From: Anita Gardner
Sent: 14 February 2018 14:06
To: Karen Parsons
Subject: FW: 93 Middleton Road application numbers M/123/17/HH and M/133/17/HH

To address your design concerns, I have modified the original scheme shown on applications numbers M/123/17/HH and M/133/17/HH in the following aspects:

EAST ELEVATION

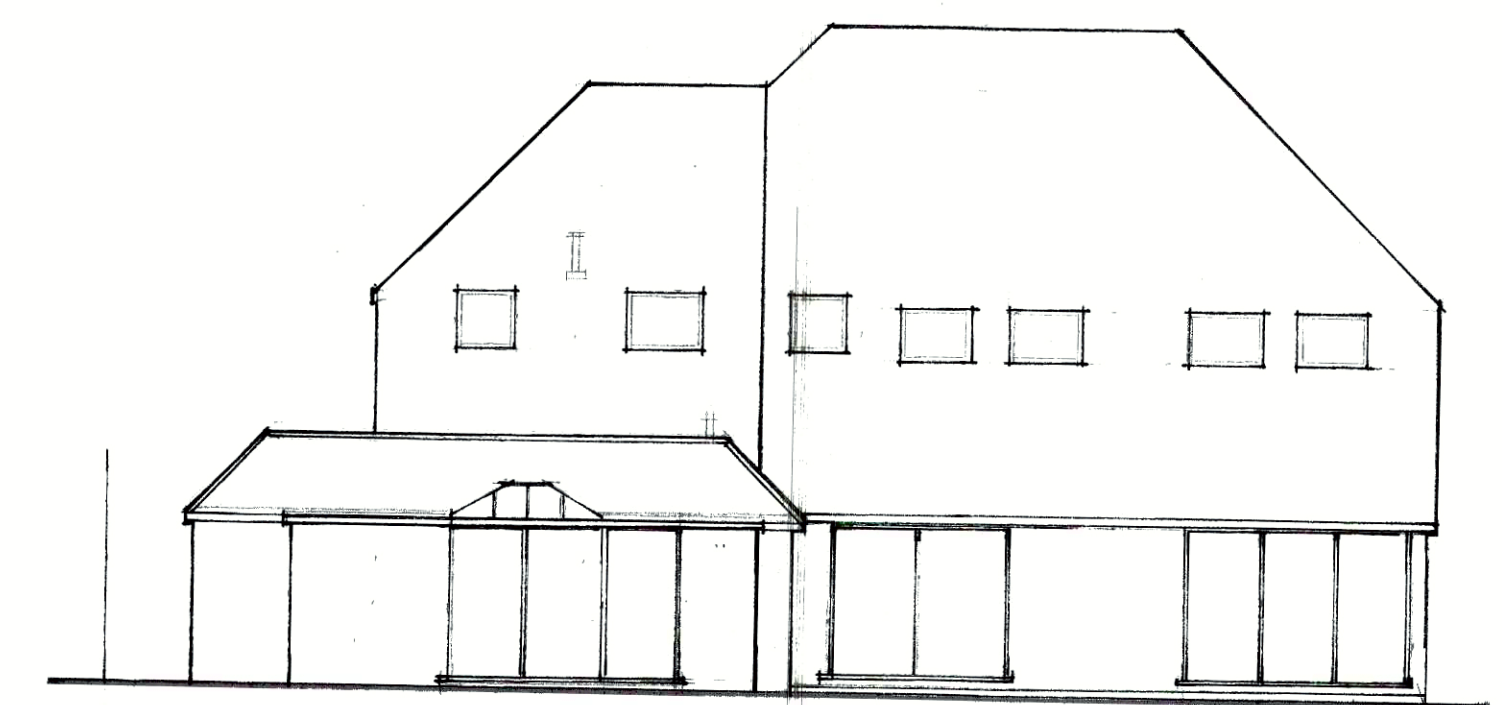
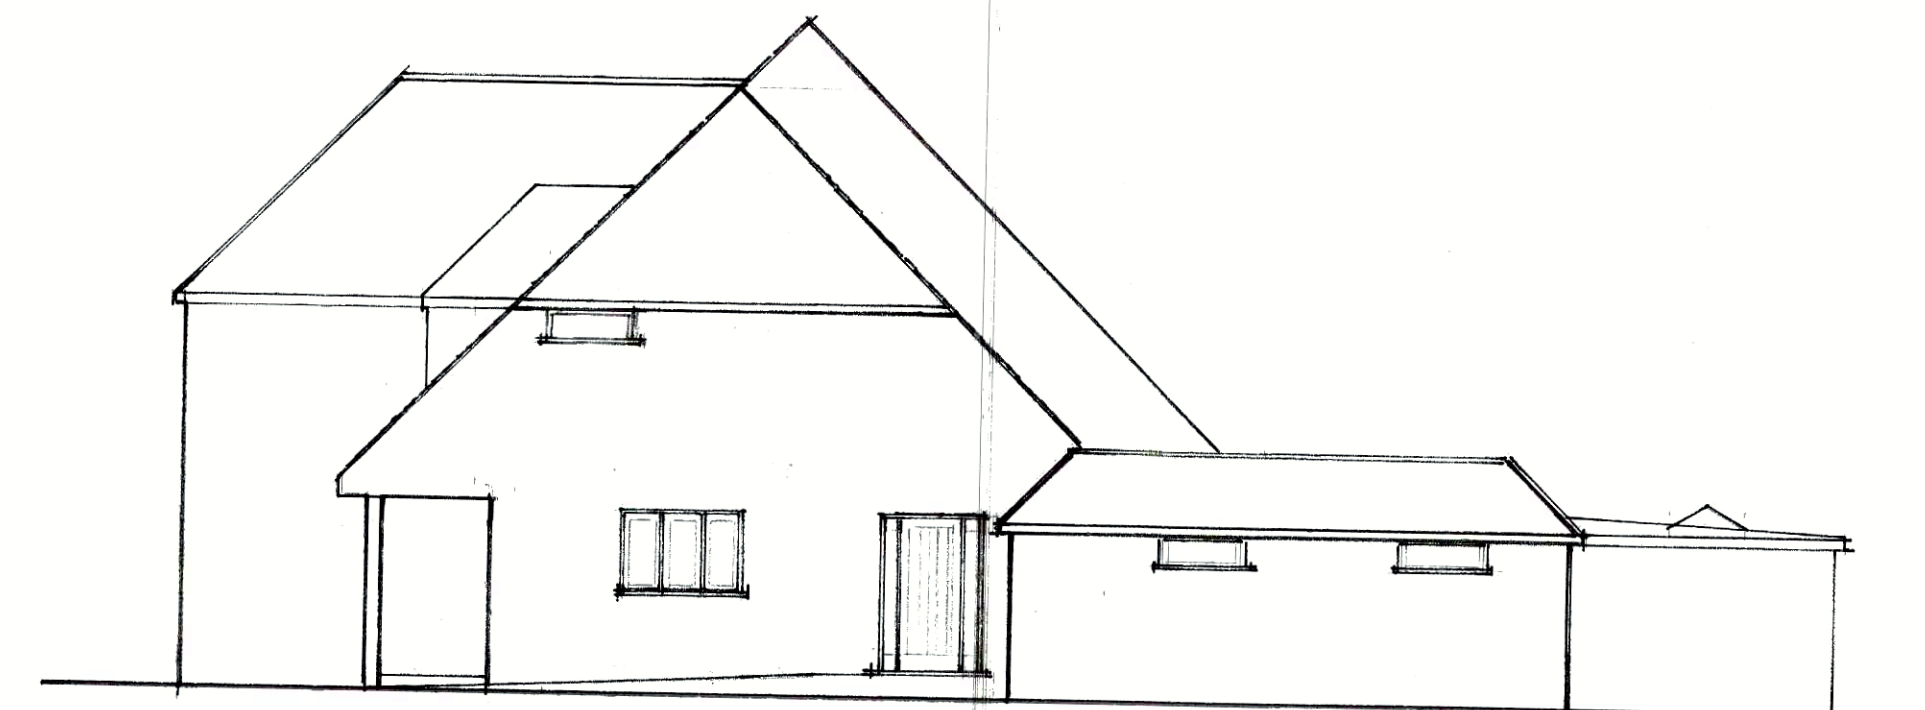
1. Moving the bulk of the extension to the front of the property predominantly on the south west side of the existing building.
2. Removing the cat-slide roof feature shown on the east elevation of the previous scheme

3. Reducing the ridge height on the east side of the building from that shown on the previous scheme
4. Only having one high level window on the east elevation (see section E on drg no AB 100 11C)

DRC N°: AB: 100 12

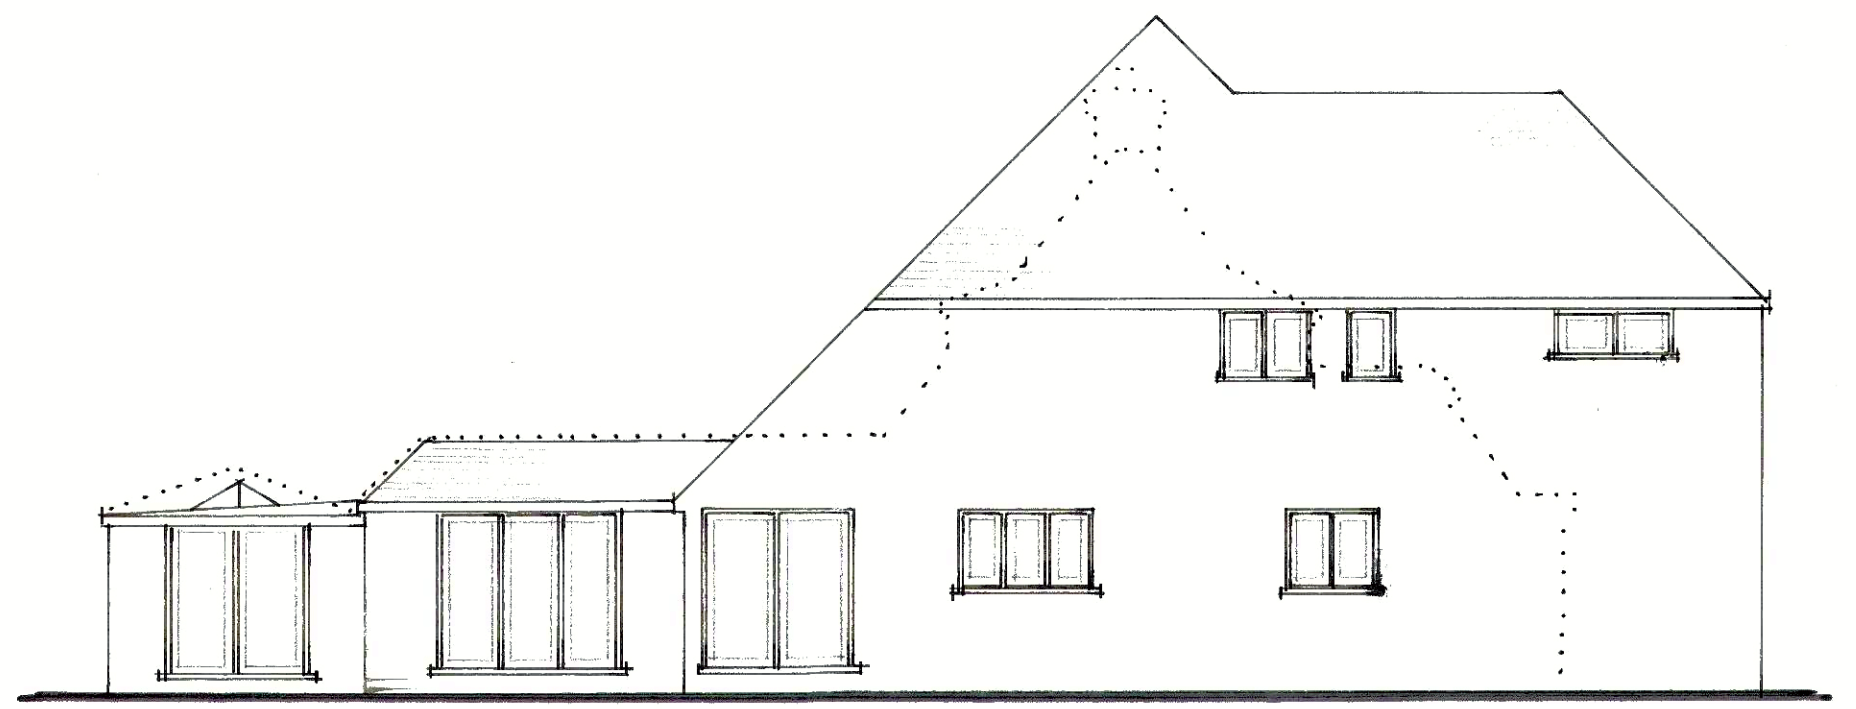
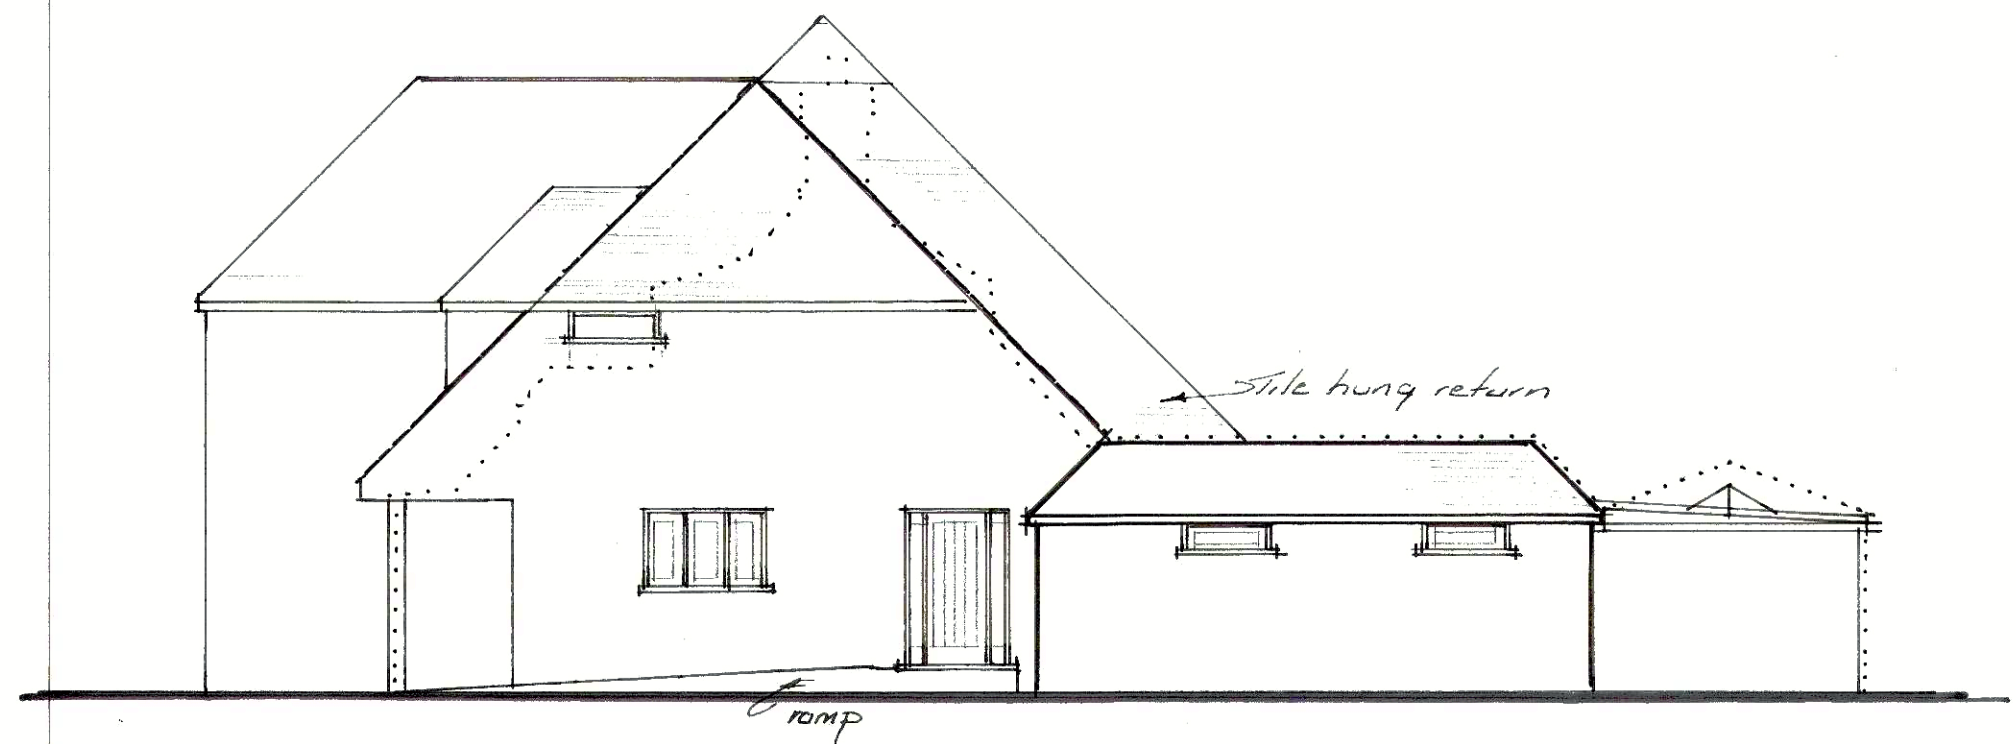
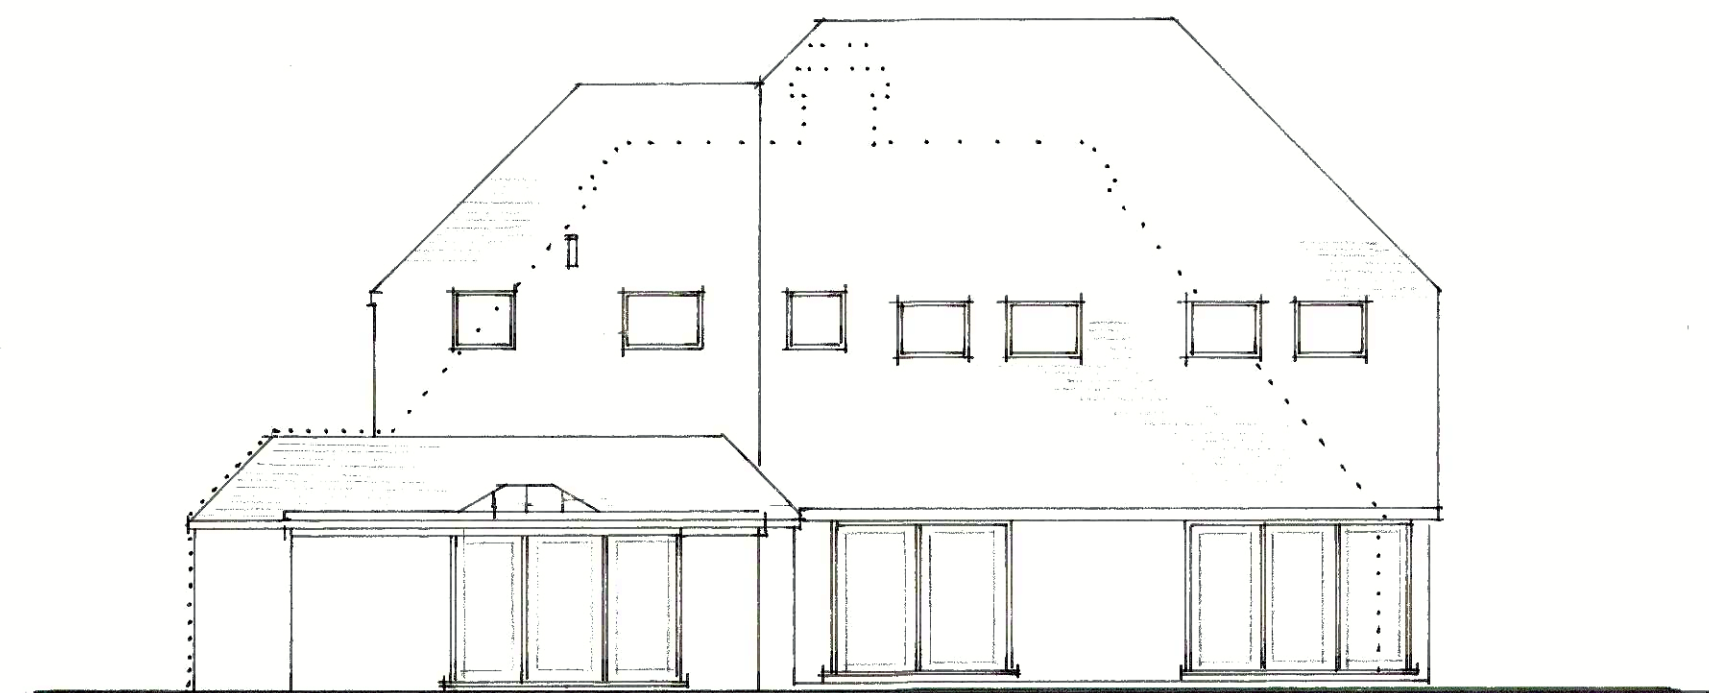
12. I have dotted the existing building outline on drawing number AB 100 12
13. To assist with your review of the street scene, I will send another email with photo shots of the adjoining properties.
